**Response to City of Sydney Comments (Landscape Architecture) on behalf of Wee Hur (Australia)  
Pte Ltd - 104-116 Regent Street, Redfern - Student Accommodation (SSD-12618001)**

**Our ref: Response to COS PR149106 060922**

Figure 18 Project Proposed Landscape Plans Treatments

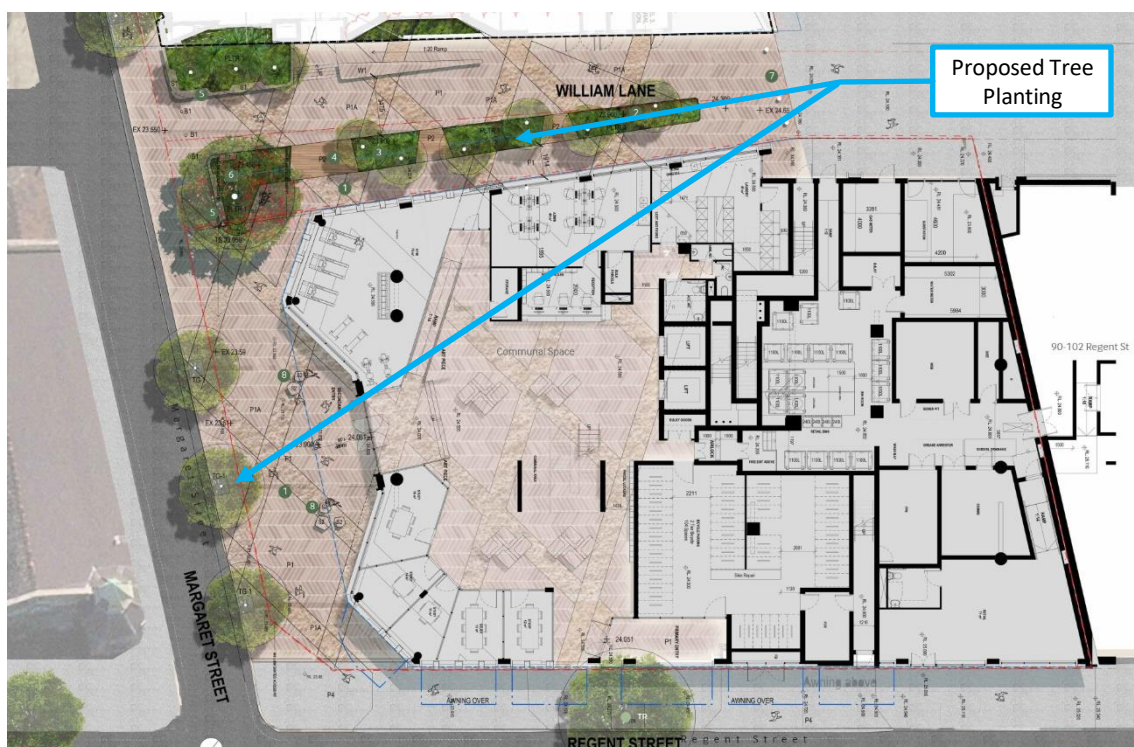
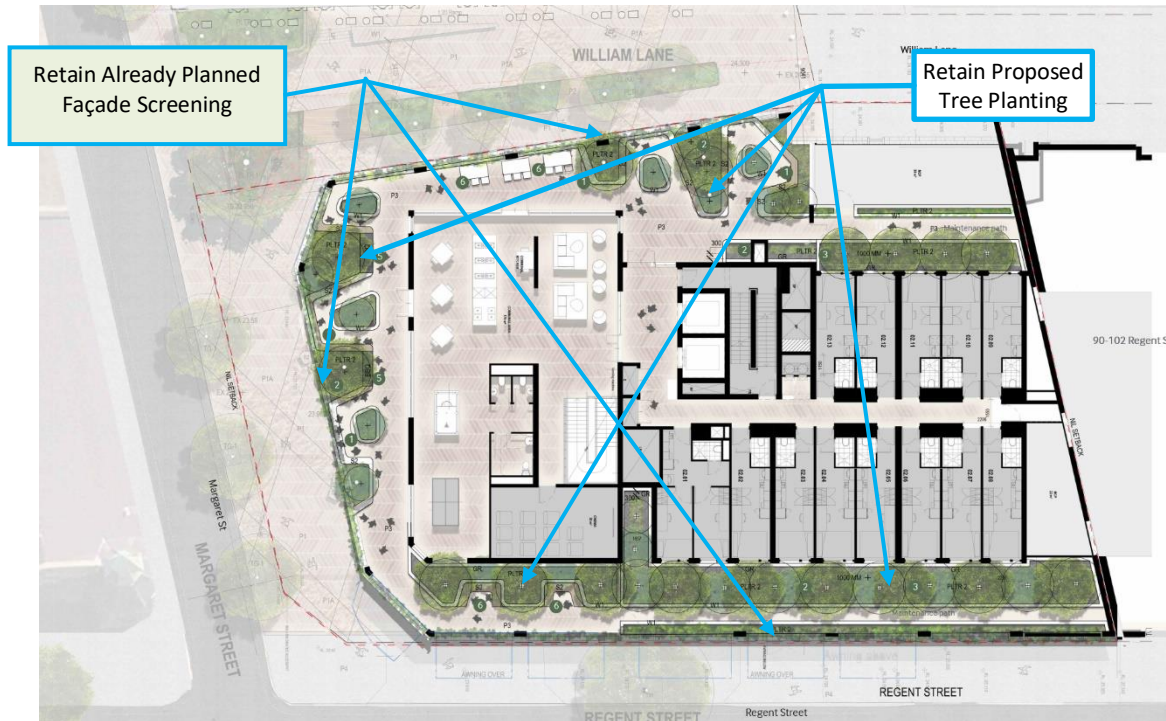
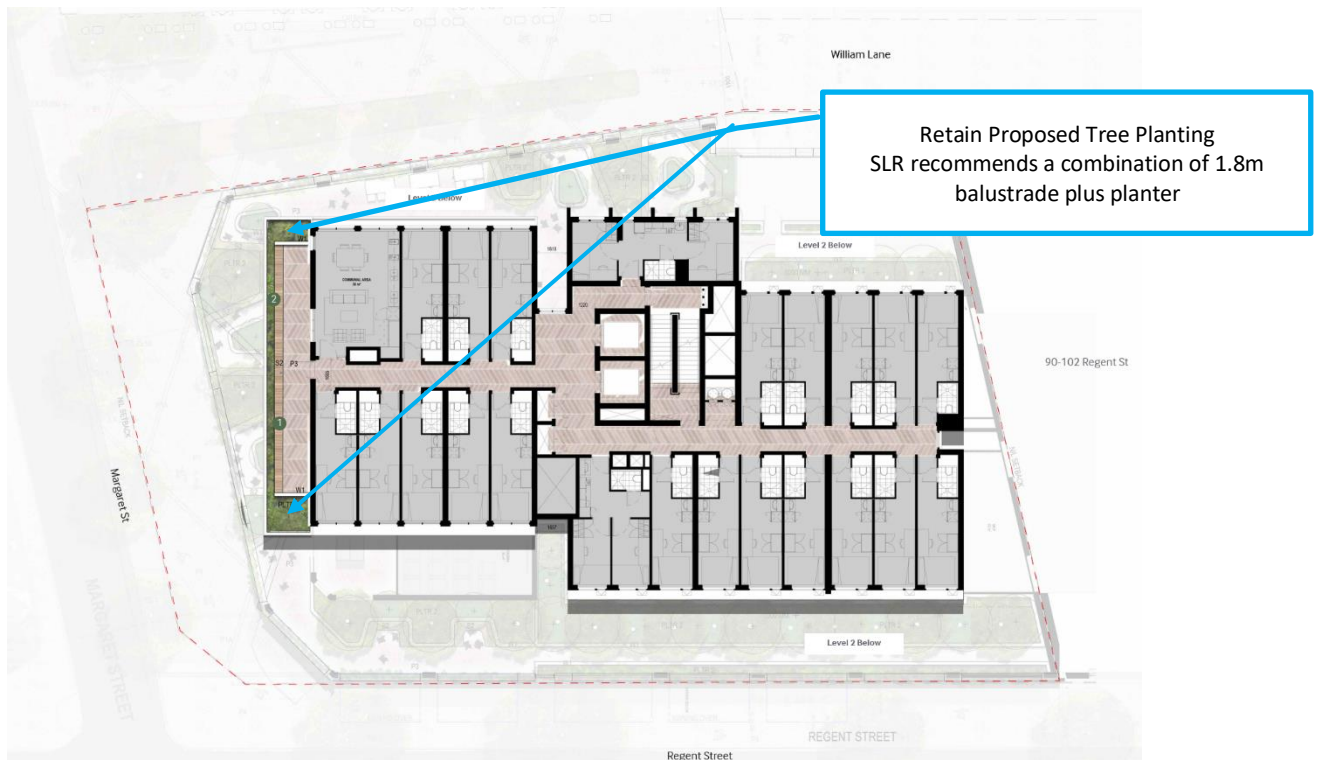
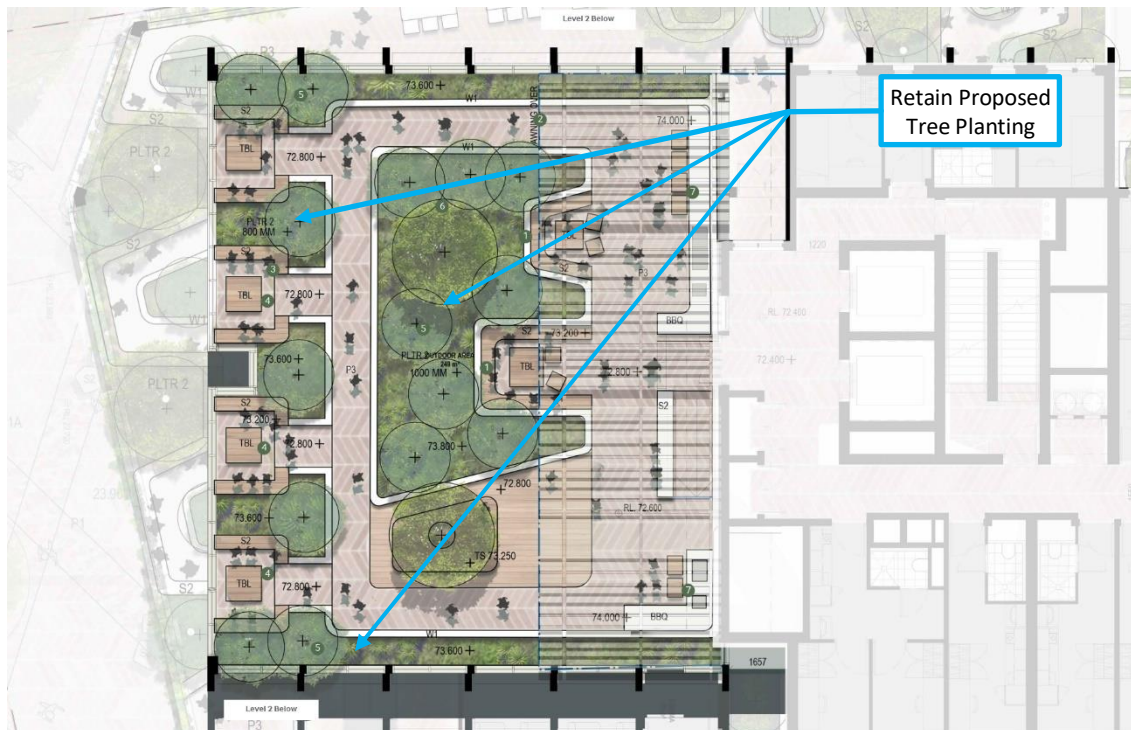
- Additionally, locations 4 and 5 within the through-site link are indicated as seating areas on the landscape plan. Therefore, further landscape mitigation measures are recommended to be implemented to achieve the required 4m/s wind criteria for sitting prescribed by Sydney DCP 2012.

- Trees on the Level 2 communal terrace include 31 small sized trees in integral and GRC planters. These trees are located at close centres ranging from 1.8 to 2.8m spacings. The updated wind report notes that wind tunnel testing found several points on the Level 2 and 16 communal open space areas with predicted 5% exceedance levels for standing. To meet the wind report mitigation recommendations and to achieve the Sydney DCP 2012 standing criterion, extensive tree planting is proposed at close centres in raised GRC planters is recommended. However, Level 2 trees in GRC planters are located to maintenance access areas only. The planters are at 1.8m centres in planters with 3.61 cubic metres of soil volume, which is significantly less than the minimum 9 cubic metre per small sized tree required by the City's Landscape Code. These trees are 1.2m from the façade edge and will suffer from crown suppression and unlikely to reach maturity required for urban canopy targets.

- *We note that these works are currently outside of the project boundary and will be addressed in the upcoming DA modification*

*In order to achieve the best possible vegetated outcome on site we have:*

- *Subject to budget reviewed the unit GRC planter dimensions with a view to encourage overlapping root zones and achieve a greater m<sup>3</sup> per tree*

- *Ensured no net loss of trees as a result of the architectural changes to level 1*
- *We note that a good percentage of the seated areas provided for users on level 16 are under pergola and therefore will be protected. The design team will also consider further shelter units to the proposed seating areas on level 2. This can include a vegetative or solid screen element to the rear and side of the shelter to afford further protection for the user.*

- *Ensured that the wider planter to the east (maintenance path) is located to the outer edge to enable maximum canopy development. Trees specified include tall and narrow Elaeocarpus to these areas and will provide a natural wind break*

- *Maximised soil volume for trees adjacent to the new internal study location to the west*
- Level 16 includes 10 trees at close centres located in a central integral planter 700mm high that rely on mounding to achieve minimum 1m depth required for tree planting. There are perimeter GRC planters with shrubs. No planting plans have been submitted, only a plant schedule. A reliance on living evergreen trees to mitigate wind on upper levels of a building is problematic if the trees fail. The design is a poor outcome and not supported from a landscape perspective.
